A303 Sparkford to Ilchester Dualling Scheme TR010036

8.17 Statement of Common Ground with Wessex Water

STATEMENT OF COMMON GROUND

This Statement of Common Ground has been prepared and agreed by (1) Highways England Company Limited and (2) Wessex Water.

A303 SPARKFORD TO ILCHESTER DUALLING
WORKS PLANS REGULATION 5(2)(J)
SHEET 2 OF 4

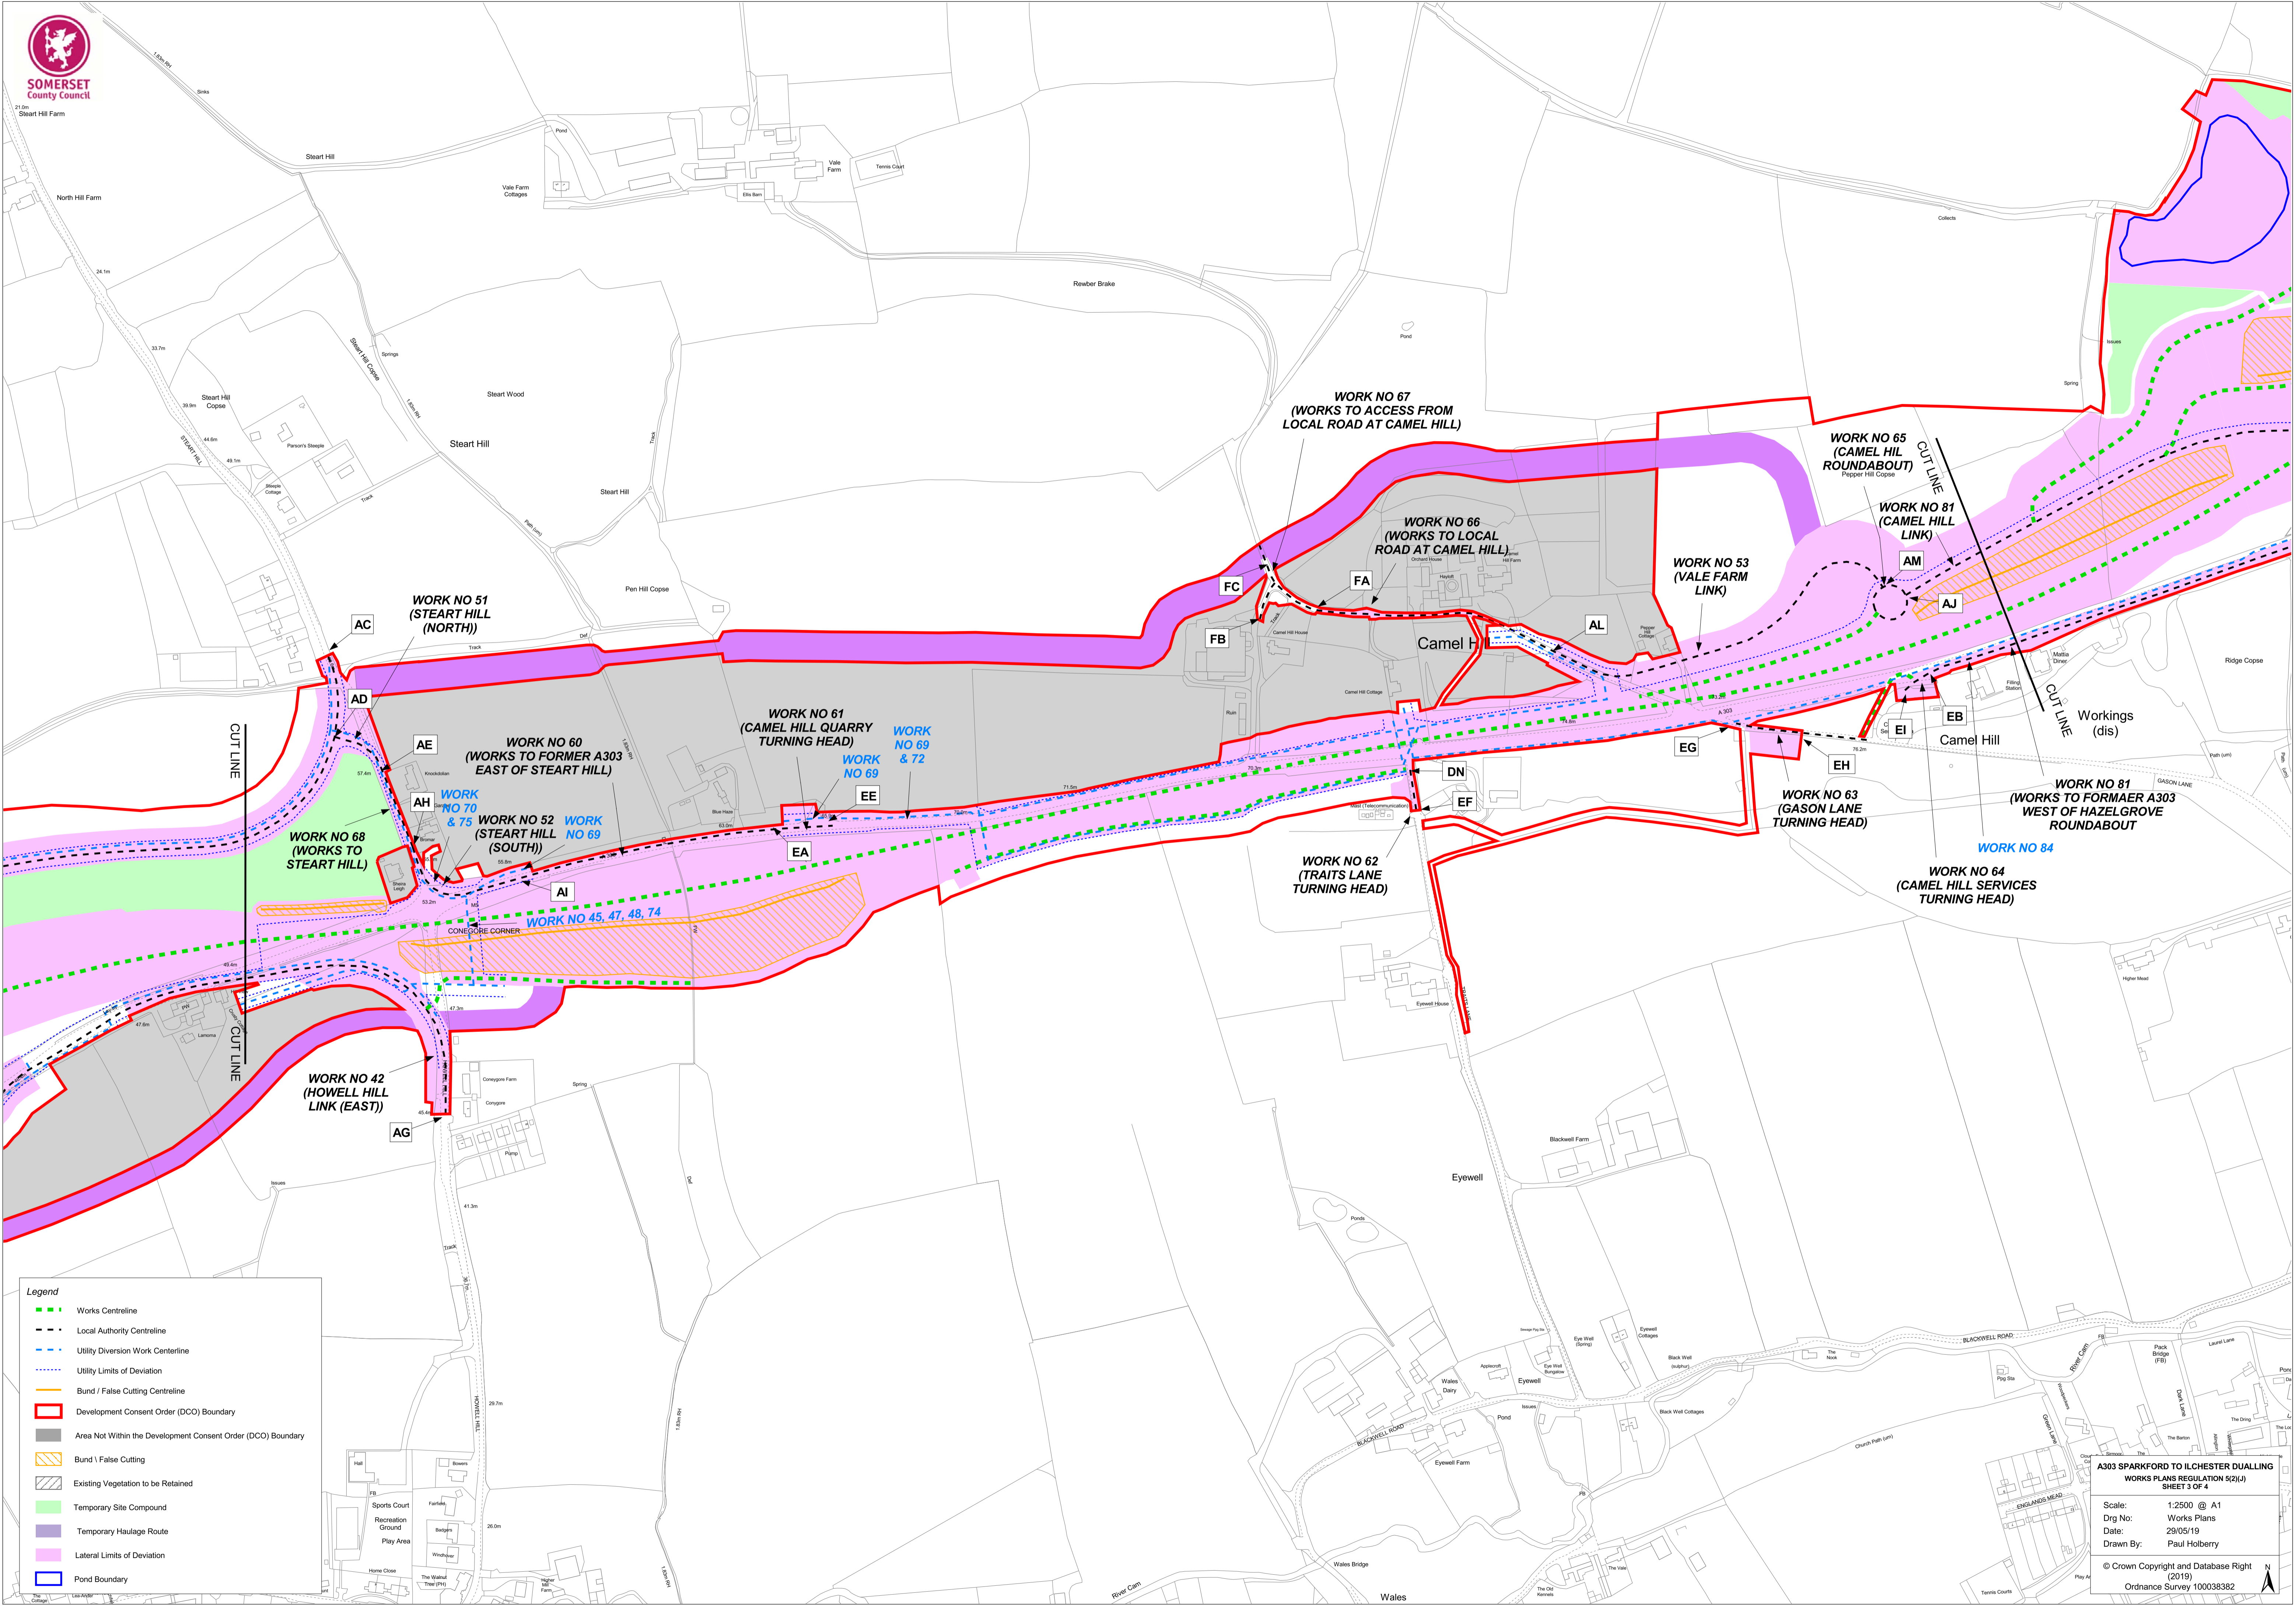
Topic	Sub-section	Wessex Water comment	Highways England response	Status
Mitigation of the effects of the project on the transmission/distribution systems	Sch 1. Work No.32 – The diversion of 500 metres of water distribution apparatus, shown on sheet 2 of the Works Plans between points JD and JJ.	Appears acceptable subject to notes below.	Noted	AGREED
	Sch 1.Work No.44 – The diversion of 1470 metres of water supply apparatus, shown on sheets 2 and 3 of the Works Plans between points JR, JS, JN, JO and KA.	Appears acceptable subject to notes below.	Noted	AGREED
	Sch. 1 Work No.46 – The diversion of 250 metres of water distribution apparatus, shown on sheets 2 and 3 of the Works Plans between points JU and JX.	Appears acceptable subject to notes below.	Noted	AGREED
	Sch. 1 Work No.74 – The diversion of 320 metres	Agreement will need to be made as to the relocation of existing	Agreed. Paragraph 7(1) of the protective provisions within the draft DCO	AGREED

A303 SPARKFORD TO ILCHESTER DUALLING
WORKS PLANS REGULATION 5(2)(J)
SHEET 3 OF 4

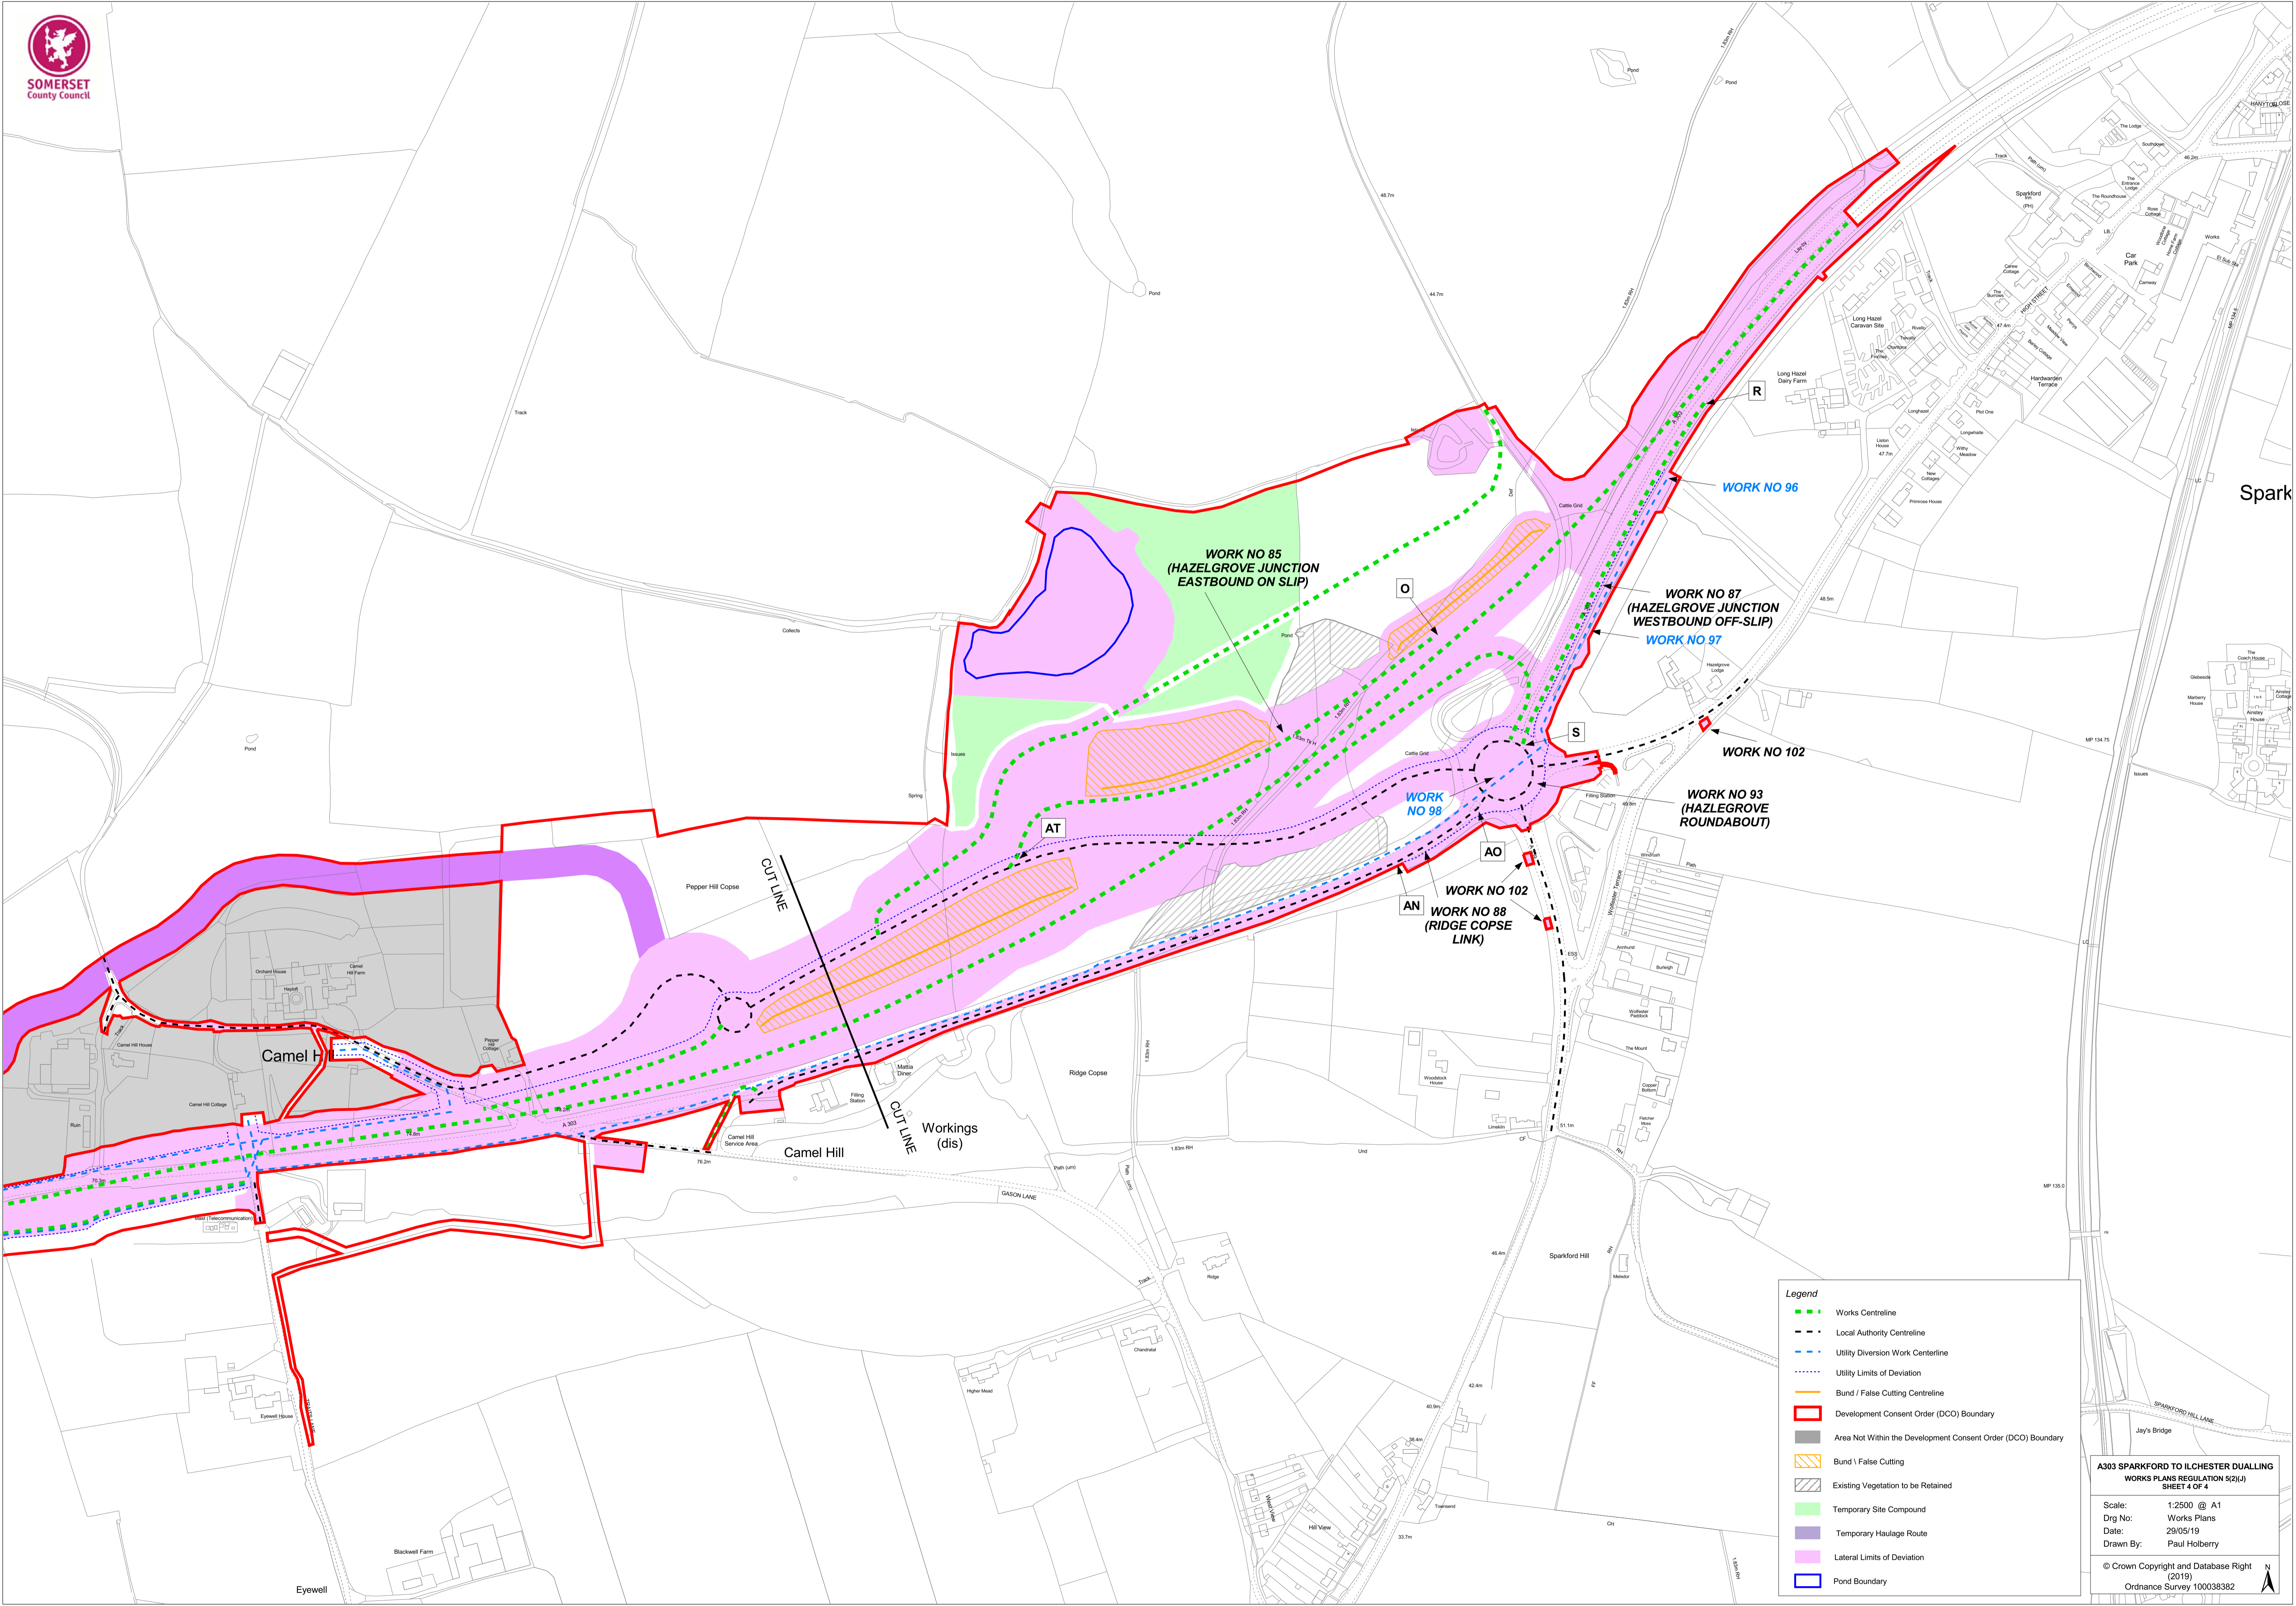
Topic	Sub-section	Wessex Water comment	Highways England response	Status
	of public sewer, shown on sheet 3 of the Works Plans between points JX and KP.	manholes, maintaining suitable cover levels and dualling the sewer to lessen the risk of Highway works in the future.	(Schedule 8, Part 1) provides that any relocated apparatus must be constructed and be in operation to the reasonable satisfaction of the utility undertaker before any existing apparatus is removed. It is anticipated that Highways England will design and construct this sewer diversion in accordance with the Specifications in Sewers for Adoption. Design will take place in the second half of 2019 and Wessex Water will be consulted during this process.	
	Sch. 1 Work No.77 – The diversion of 50 metres of water distribution apparatus, shown on sheet 3 of the Works Plans between points KH and KI.	Mains level to be altered with the road and contained within a duct. Wessex Water will require the provision of twinned ducts for all new critical crossings of the A303 in order to ensure security of supply and lessen the risk of Highway works in the future. Specifications to be agreed and subject to the notes below.	Agreed. Paragraph 7(1) of the protective provisions within the draft DCO (Schedule 8, Part 1) provide that any relocated apparatus must be constructed and be in operation to the reasonable satisfaction of the utility undertaker before any existing apparatus is removed. Detail design will take place in the second half of 2019 and Highways England will request a detailed design and specification for this and all other works to Wessex Water's distribution system in accordance with the	AGREED
